Planning Application Ref: AL/51/19/PL

Location: Springfield and land to rear, Hook Lane, Aldingbourne, PO20 3TE

Description of works: Demolition of the existing dwelling & erection of 3no. 2-bed, 3no. 3-bed & 4no. 4-bed dwellings, access, landscaping & associated works

Comments on Application:

Drawing Title		Drawing No.	
Engineering Details		KNC1932	
Drainage Strategy		602-01	
Drawn	Checked	Scales	Page Size
KN	KN	1:250	A1
Job No.	Drawing No.	Date	Revision
KNC1932	602-01	09.19	A

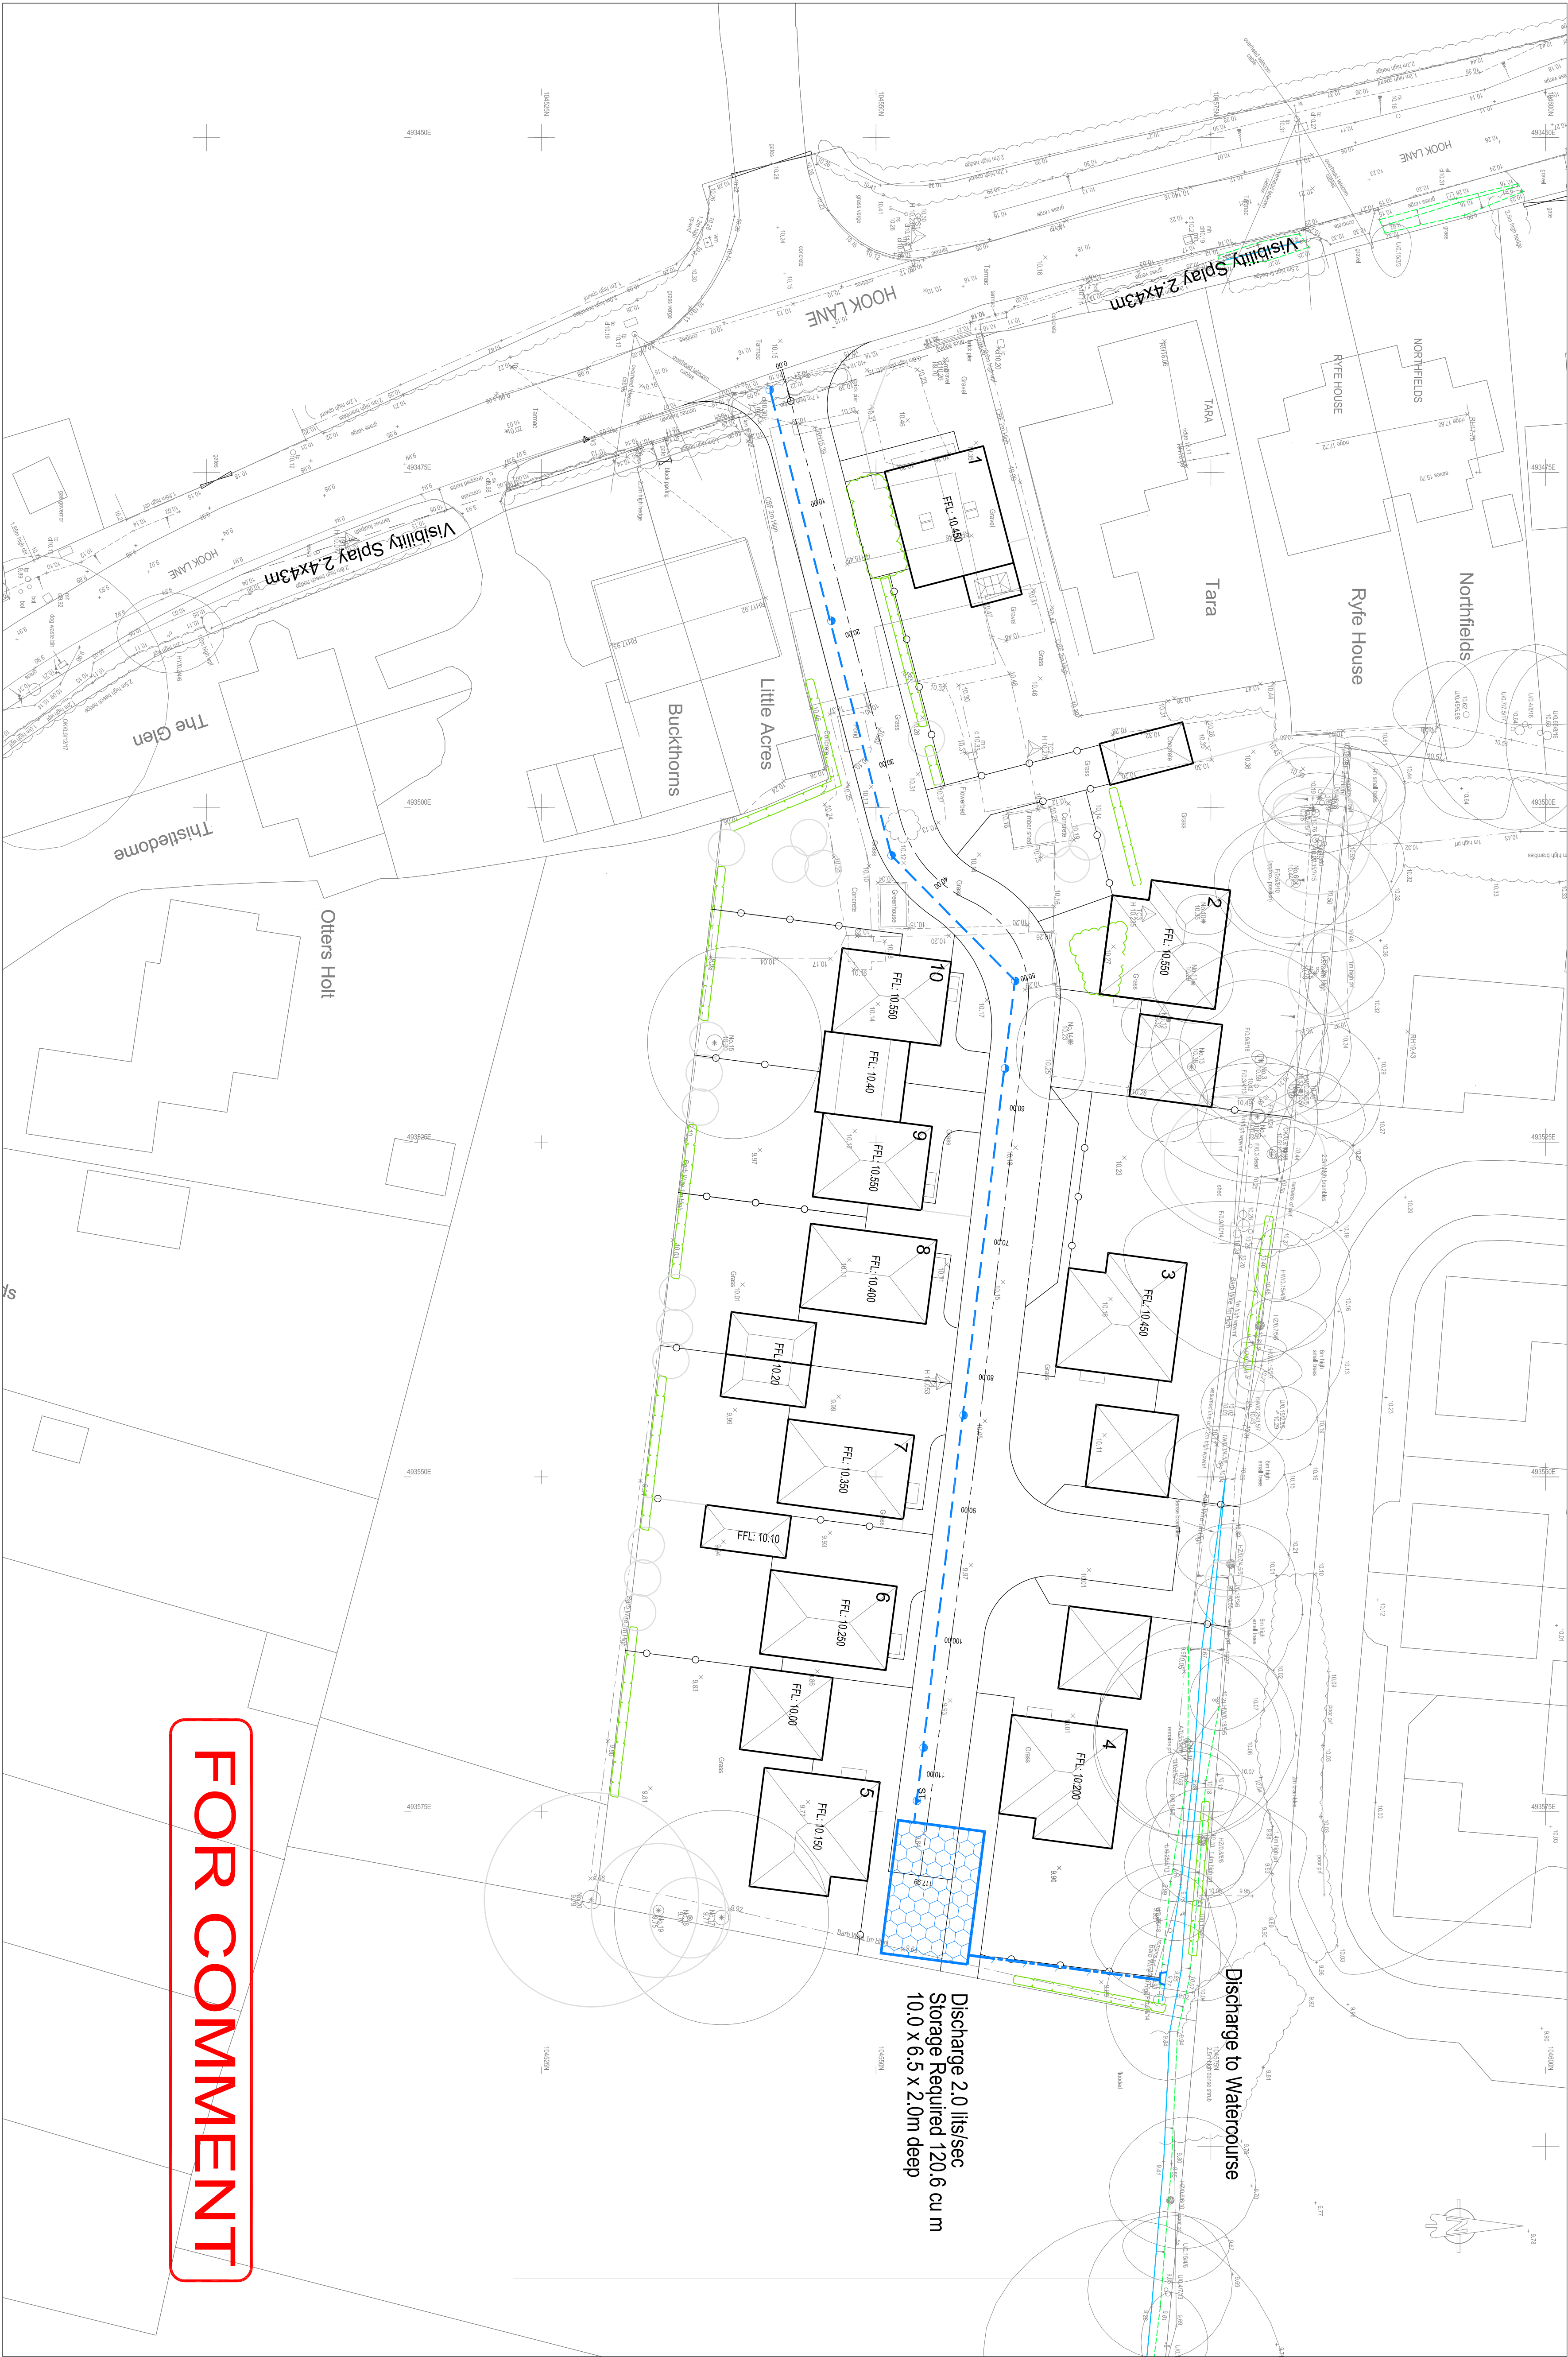
- I have subsequently been able to note the following plan: Engineering Details Drainage Strategy, dwg.no. 602-01, Rev A, 09.19. This shows what I assume to be a subterranean construction (attenuation tanks?) well within the root protection area of an off-site oak tree. That oak tree (T23) is a Category A tree and the subject of my recommendation for statutory protection (Tree Preservation Order). It has not been shown on the above plan. Outwardly and from a distance it appears to have high growth potential. The root protection area of this tree should remain sacrosanct – as shown on the Tree Protection Plans.

- Should this application proceed to development then the drainage strategy would have to be revised to avoid incursion into the RPA of off-site tree T23, the most valuable tree overlapping the development. The potential for expansion of its root system would also have to be taken into account as part of that revision.
